REQUEST

Current Zoning: N1-A (neighborhood one)
Proposed Zoning: R-8(CD) (single family residential, conditional)

Approximately 1.77 acres located on the south side of McKee Road, east of Weddington Road, and west of Savannah Hills Drive

The petition proposes to redevelop the existing single family home/lot with a total of 14 units, with two triplexes and two quadruplexes on individual lots for a site in southeast Charlotte.

REZONING
TECHNICAL
DATA SHEET

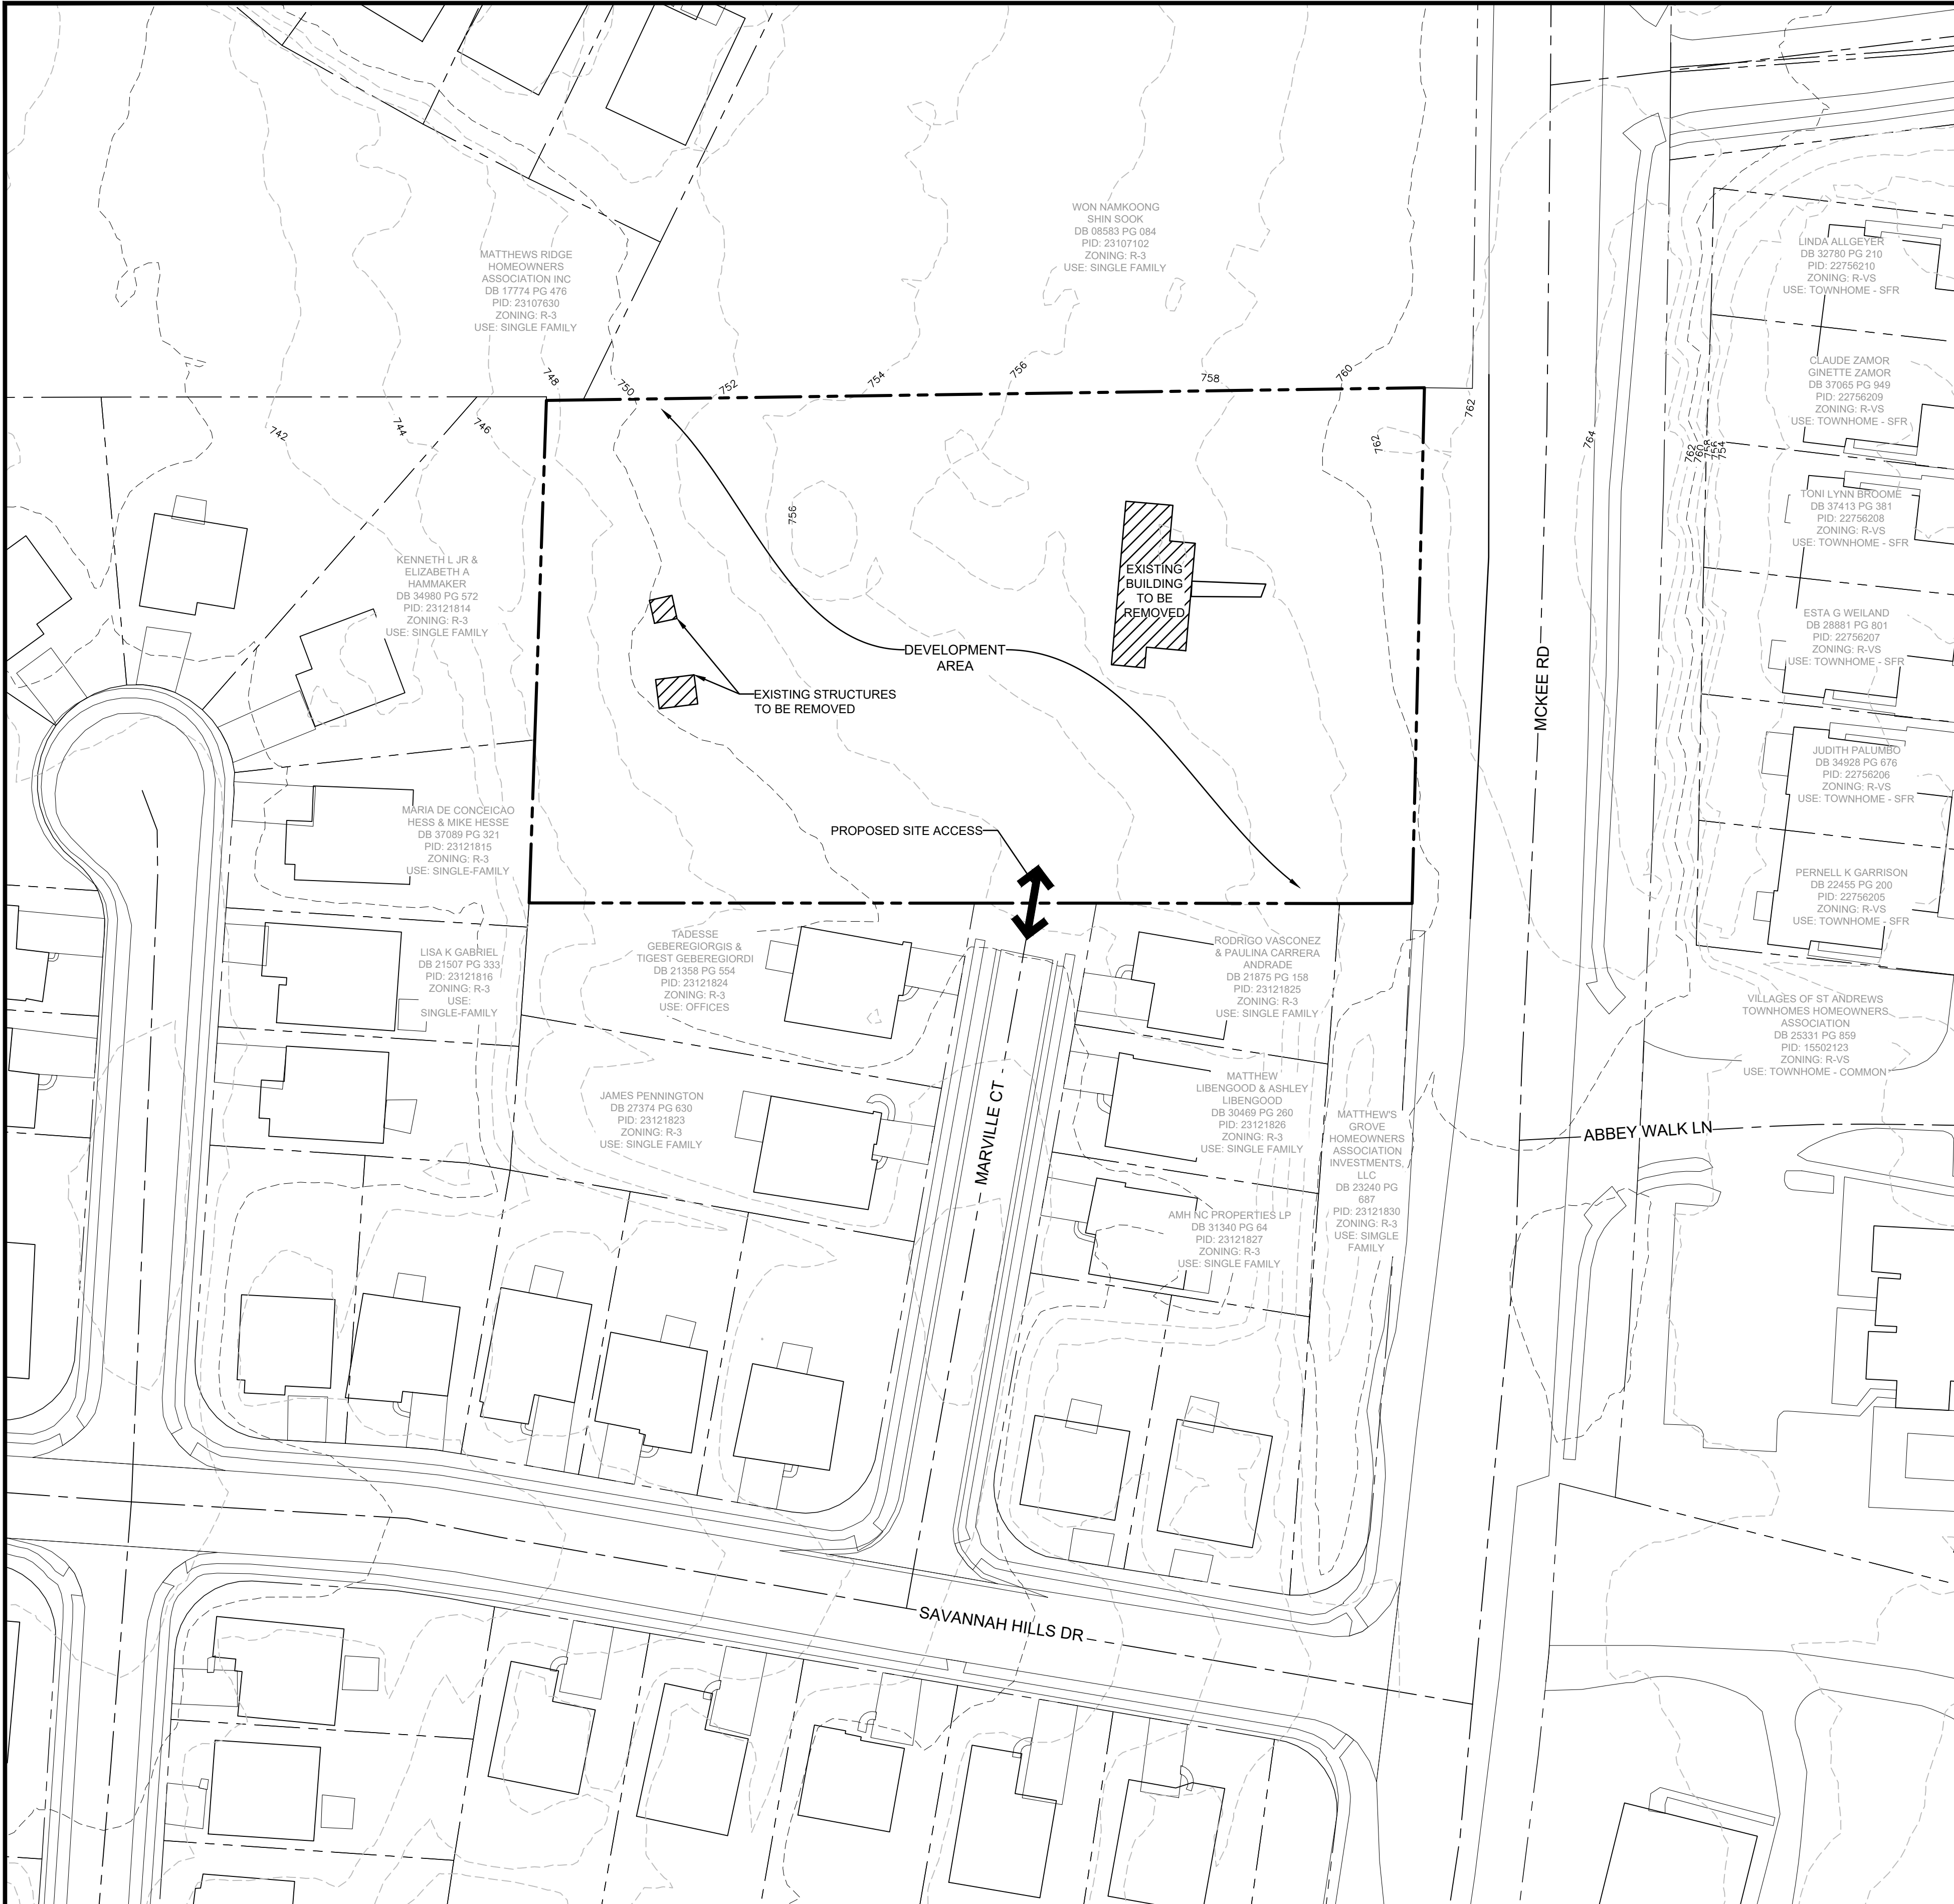
3. ~~Refine Open space note 5.2 to clarify what is required, show desired tree preservation area on the site plan or provide a minimum width/buffer area of trees that should remain.~~ Addressed, note was deleted.

4. ~~Verify with Subdivision if 12.308 applies to this development. If so the 20 rear yard is measured from the inside edge of a 30 ft landscape area/common open space.~~ Addressed, 20 ft rear yard is required.

5. ~~Verify internal side yards shown on plan as they appear larger than 5 ft.~~ Addressed
6. ~~Correct inconsistency between the development data table and site plan for front setback. The data table says 30 ft setback from thoroughfare while the plan shows 20 ft. If 12.308 applies, then a 30 ft common open space or landscape easement is required, and a 20 ft rear yard is measured from there.~~ Addressed

RZ-1

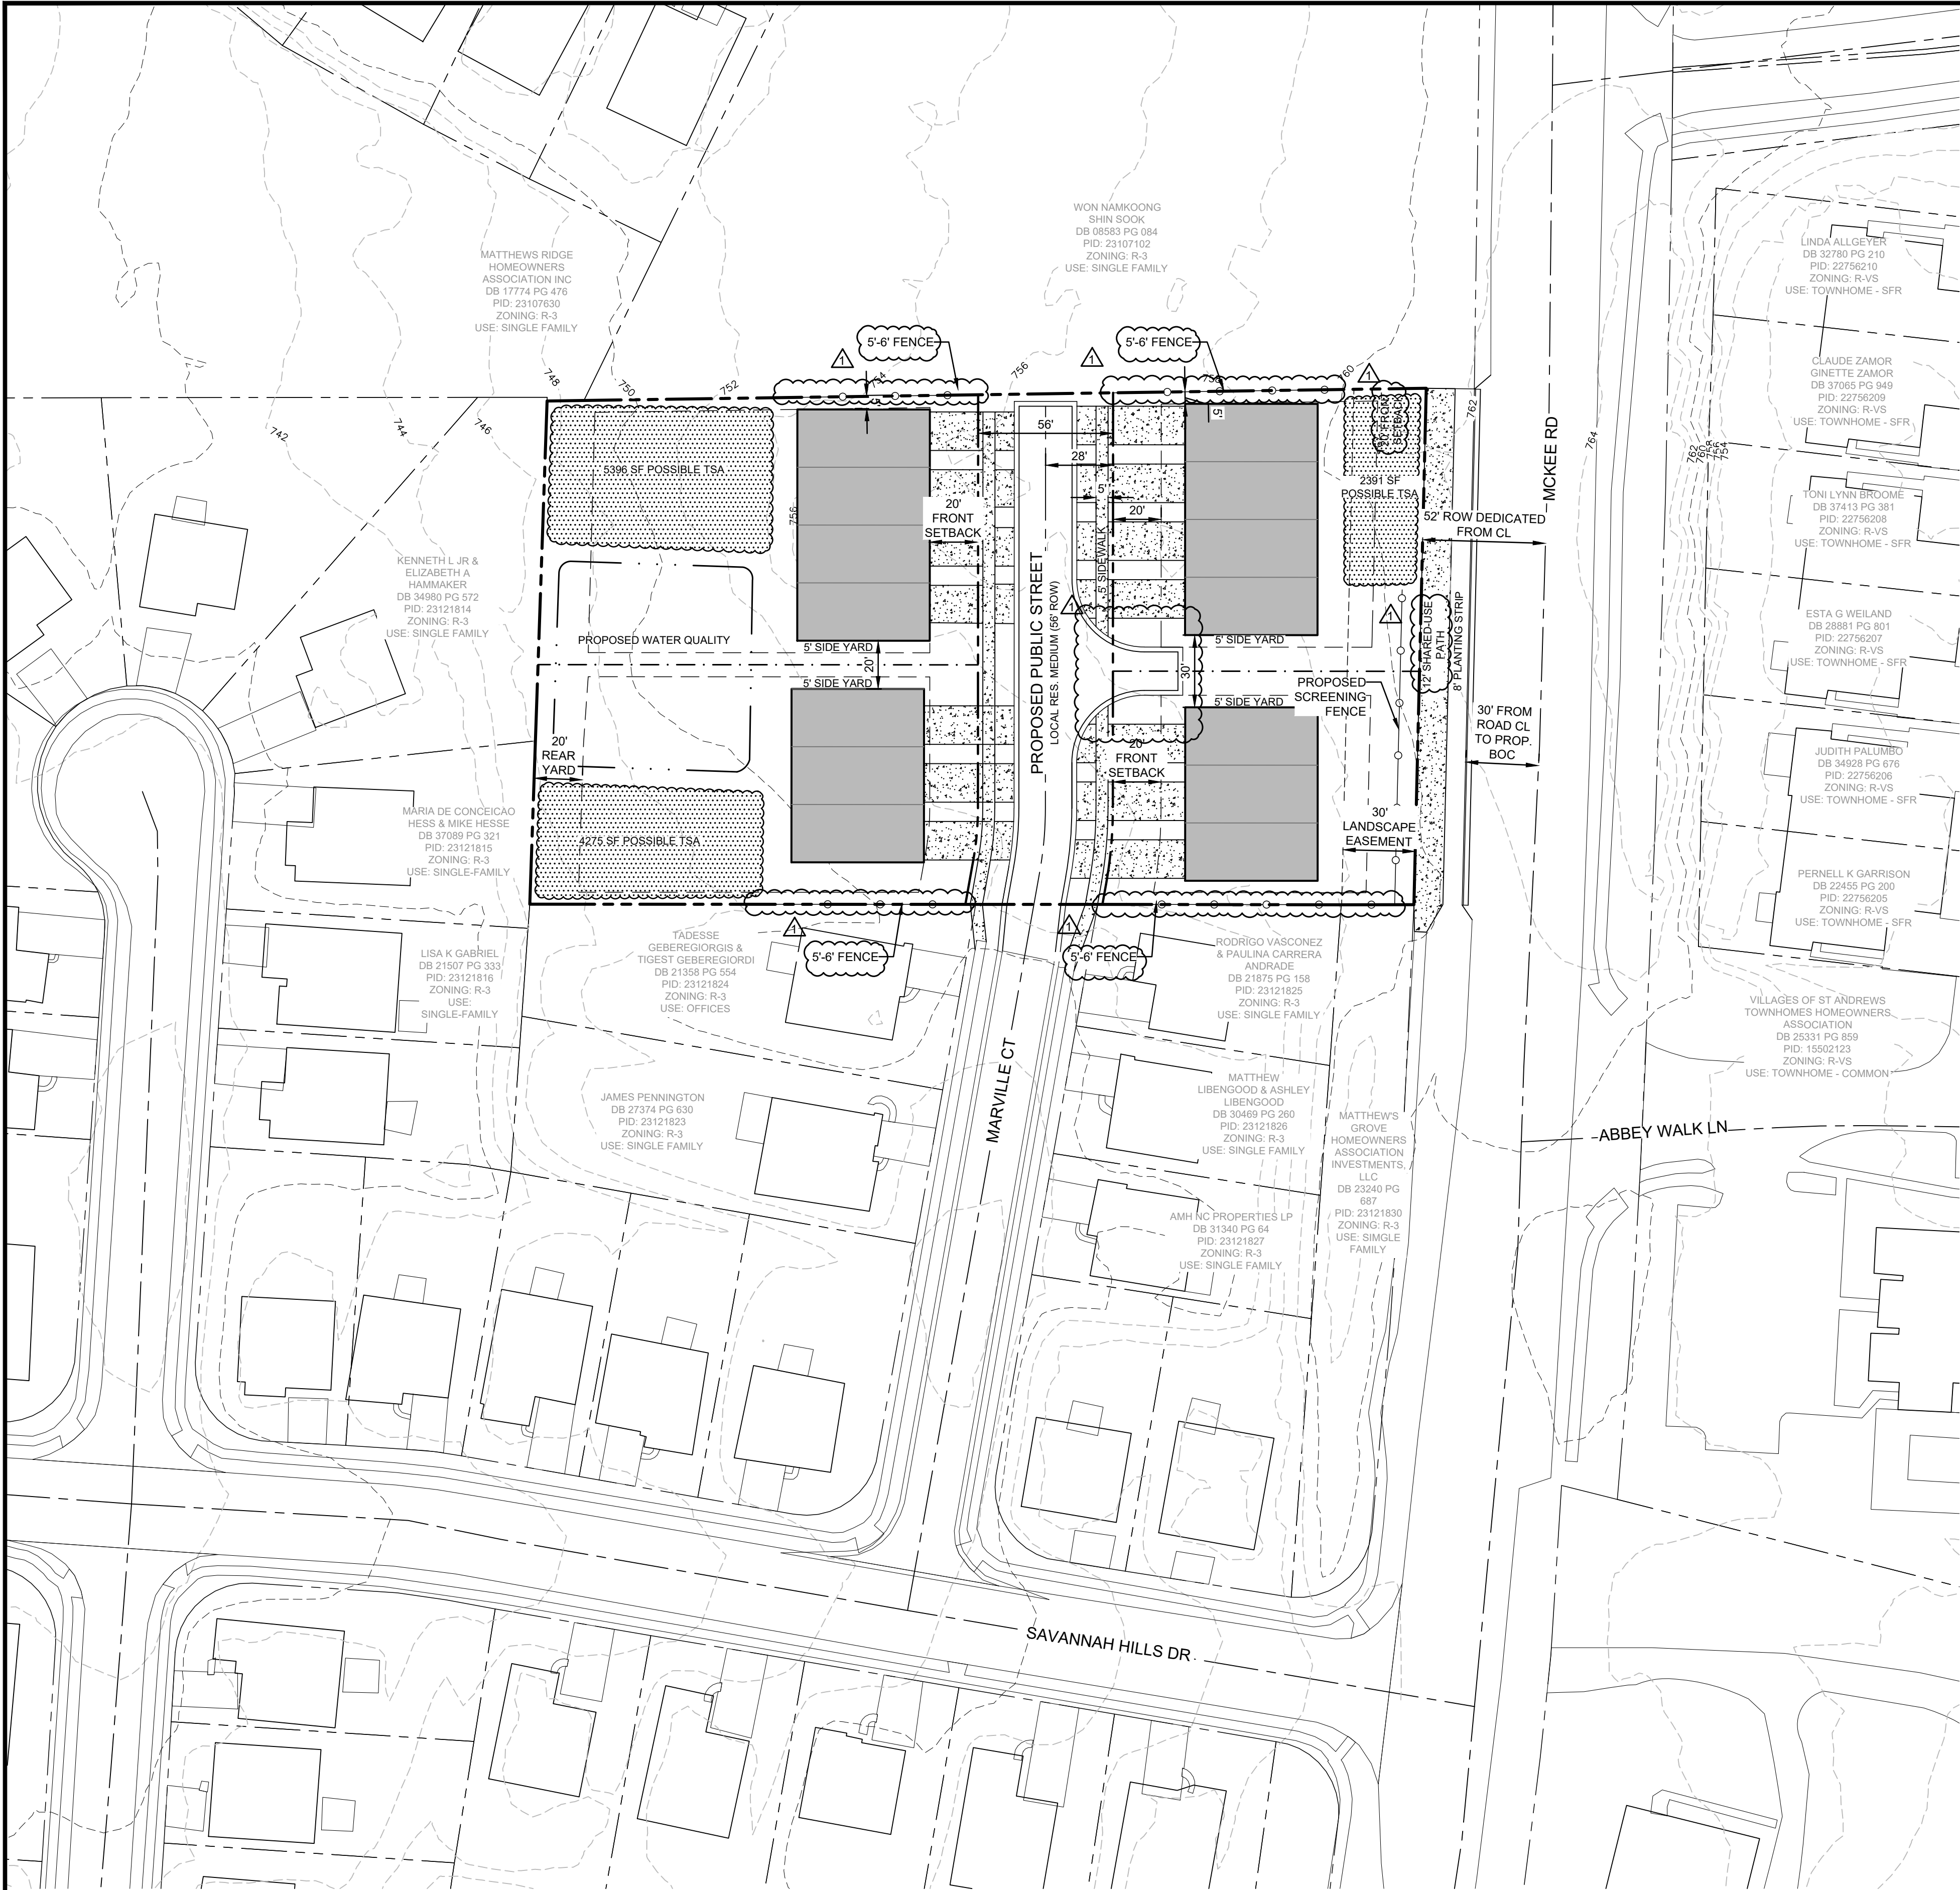
7. ~~Show potential solid waste facilities on the site plan.~~ Addressed
8. ~~The legend includes proposed and existing trees, however none are depicted on the site plan. But note 5.2 references existing trees along the eastern property line.~~ Addressed
9. ~~Delete Architectural note 4.6 as it is repeated and 4.11 as is does not apply.~~ Addressed
10. ~~Update the existing zoning in the development data to reflect N1 A per UDO translation.~~ Addressed
11. Add a commitment to provide pedestrian signage along Marville Ct.
